An
Bord
Pleanála

ABP-309770-21

Request for Further Information

To: Brendan Wyse, Assistant Director of Planning
From: Mairead Kenny, SPI
Re: ABP-309770-21 – Construction of 15 wind turbines, grid connection and all related site development works
Date: 13 April 2022

Figure 8A Wind Farm Site - Peat Depth Distribution

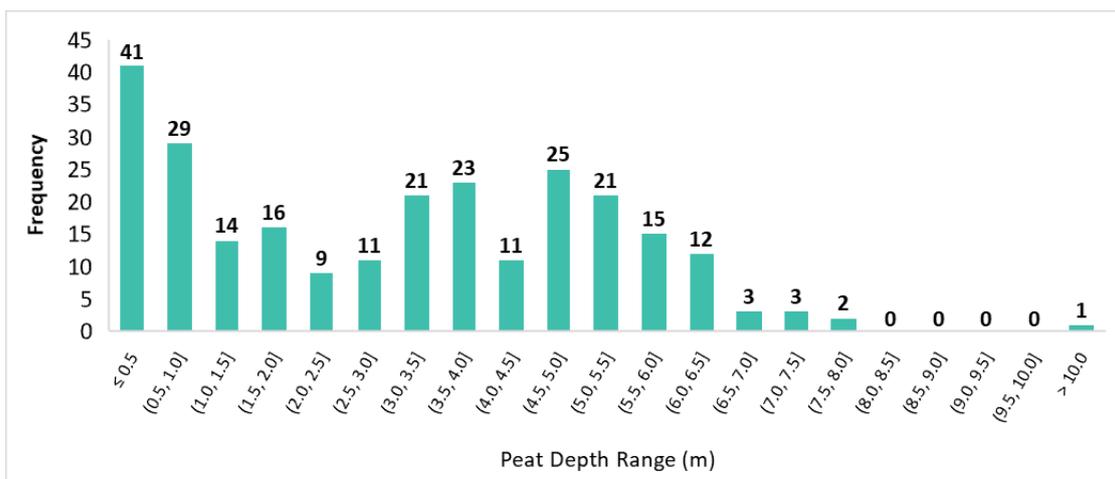
- 4.1. In section 8.3.2.1 of the EIAR it is stated that the recorded peat depth at T12 is given as 12.5m – from the 2020 rotary core boreholes while the peat depth within 50m is 4.5m based on table 8-4. You are requested to justify the location of the turbine in very deep peat and at a location where the slope angle is 3 degrees and to consider whether there is a more suitable alternative.
